Our Case Number: ABP-314724-22

Re: Railway (Metrolink - Estuary to Charlemont via Dublin Airport) Order [2022]
Metrolink. Estuary through Swords, Dublin Airport, Ballymun, Glasnevin and City Centre to
Charlemont, Co. Dublin

RE: SUBMISSION ON THE METROLINK ON BEHALF OF TANAT LIMITED REGARDING A SITE BOUND BY GEROGE'S QUAY TO THE NORTH, TARA STREET TO THE WEST AND POOLBEG STREET TO THE SOUTH.

ABP Ref. NA29N.314724

TARA STATION - LONGITUDINAL SECTION
1 : 200

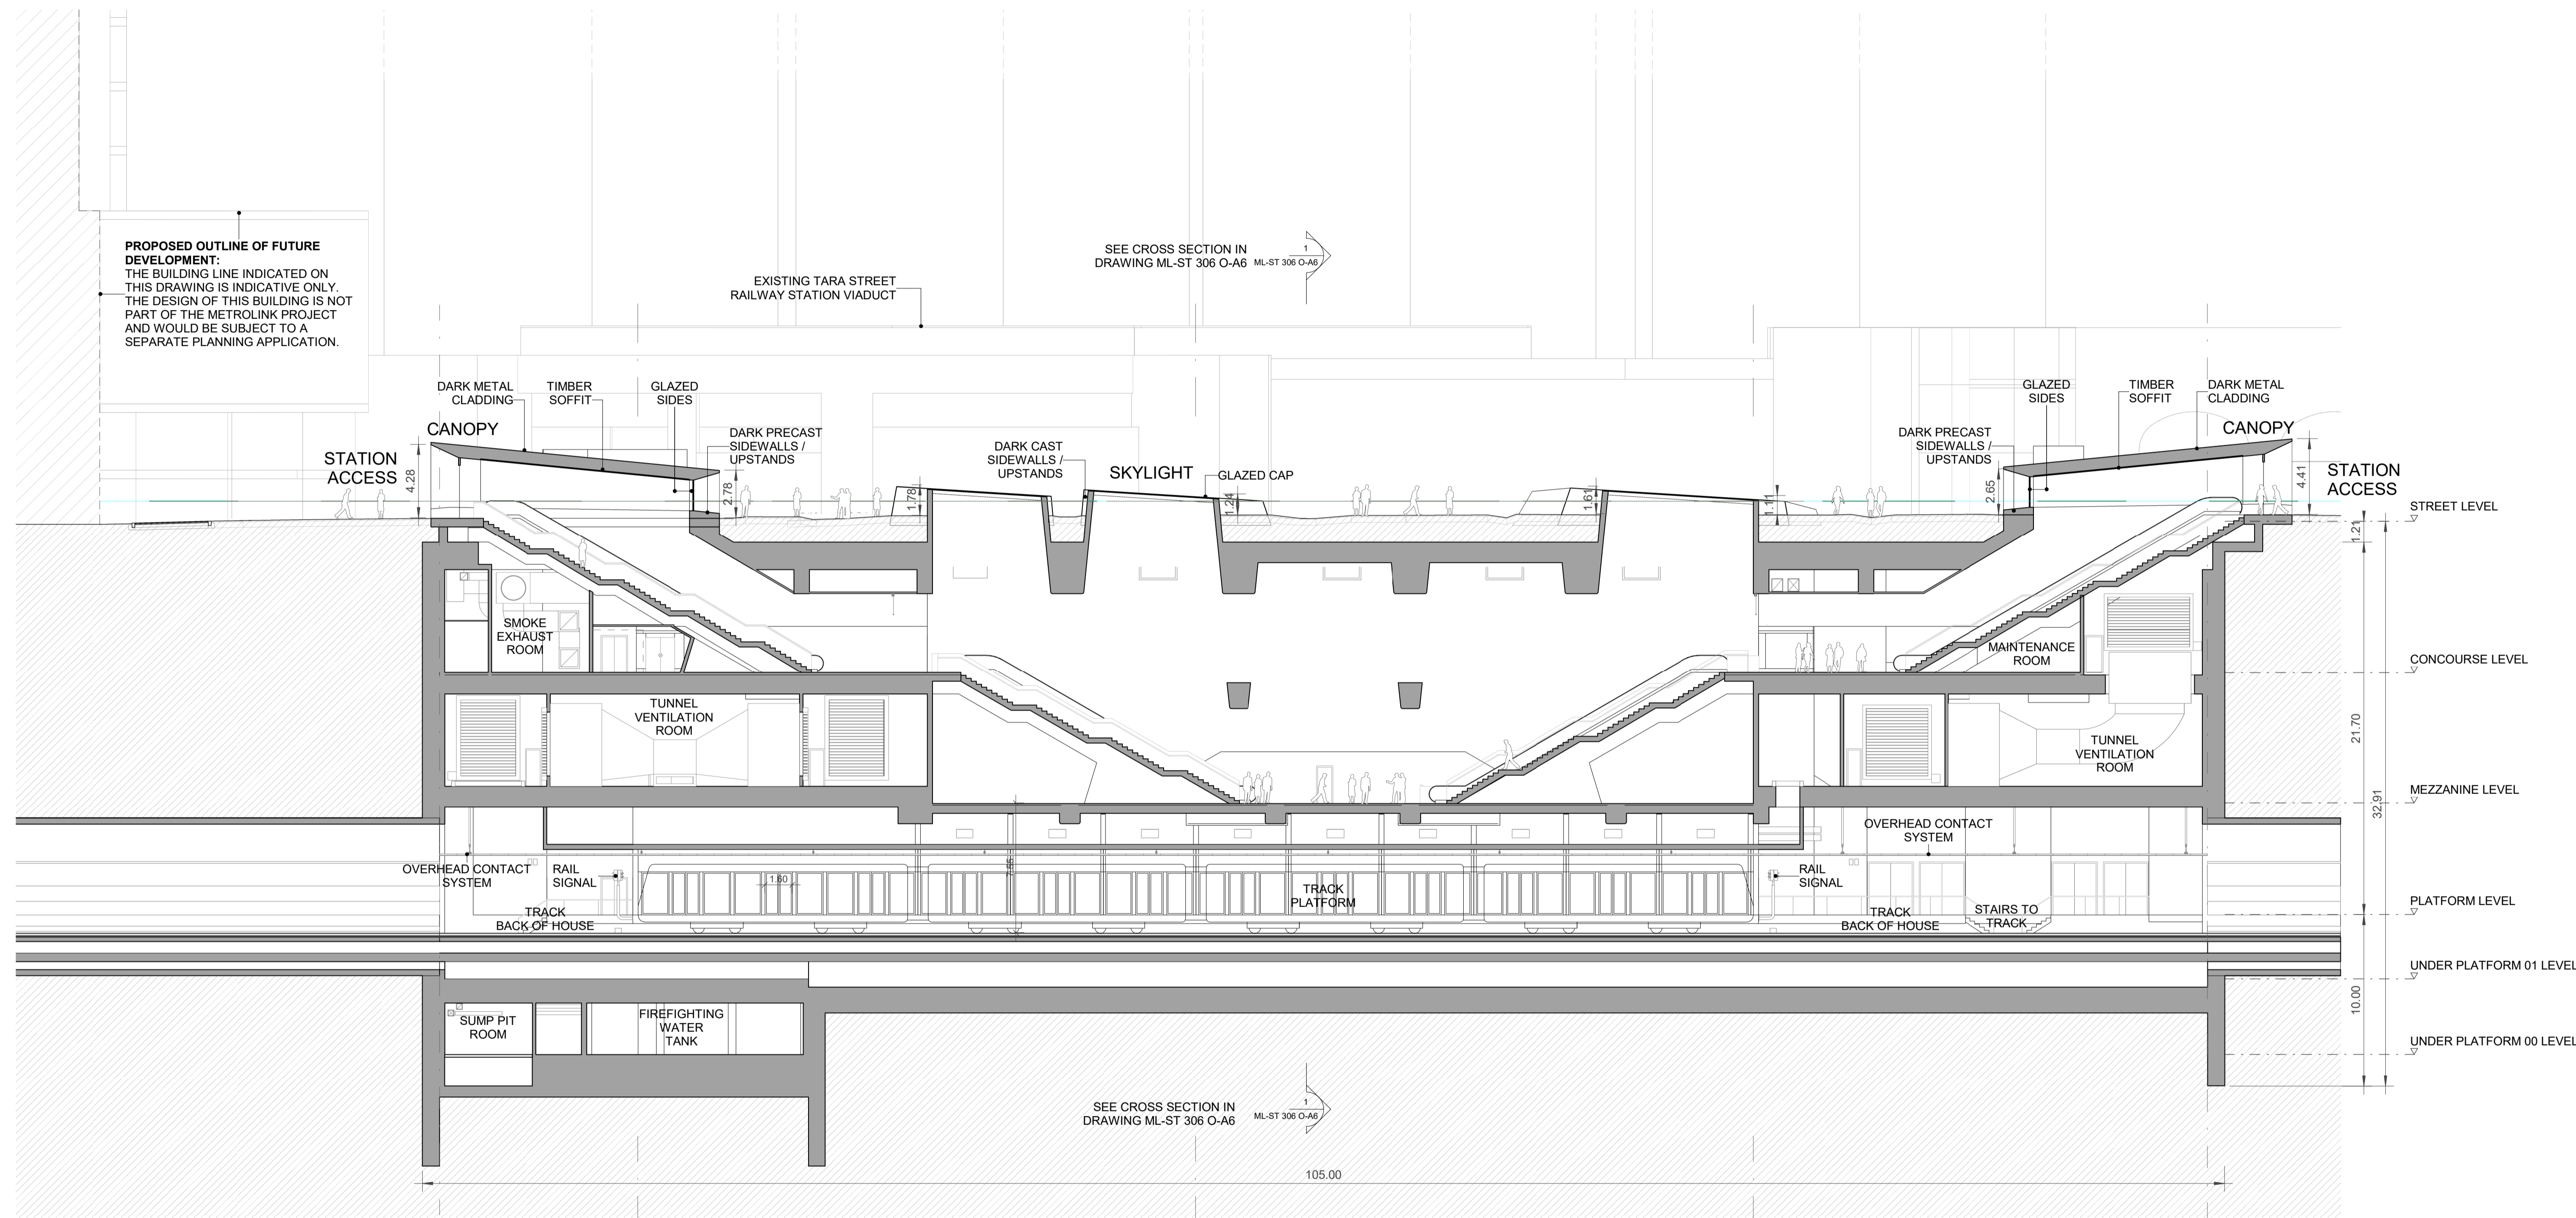
A note has been prepared by CS Consulting and is included as Appendix 1 of this submission. The Railway Order applies for a vertical deviation of 5 metres, however, the existing formation level of the basement is at -11.15m and the crown of the tunnel is at -17.4m, leaving a 6.3m gap between the tunnel and the basement of the building. Whilst it is understood a deviation may be required due to detailed design or conditions encountered, the result of such a deviation in relation to the subject property is potential minimal distances of construction from substructure and increased impacts arising in relation to noise, vibration and associated building damage. The note from CS Consulting states:

“As there is only a 6.3 metre dimension from the crown of the tunnel and the formation level of our concrete raft foundation, the above section 6.(d) ii. would not be acceptable, in which we would request that writing confirmation is needed to be provided by our client before on any deviations from the current -17.4 metre level below existing ground as indicated on the current sections.

Further to receipt of the latest MetroLink proposed works, we confirm the proposed tunnel runs directly under your building. Our building has a double level basement which as a formation level of -11.15 metre below existing ground level. We note that the proposed crown of the proposed MetroLink tunnel is at a datum of -17.4 metre below existing ground level, which is 6.3 metre below the formation level of our basement.

However, the Railway order section 6. Deviations, (d) ii. states, "deviate vertically by any distance not exceeding 5 metres upwards from the levels show on the plans" as there is only a 6.3 metre dimension from the crown of the tunnel and the formation level of our concrete raft foundation, the above section 6.(d) ii. would not be acceptable, in which we would request that writing confirmation is needs to be provided by our client before on any deviations from the current -17.4 metre level below existing ground as indicated on the current sections.
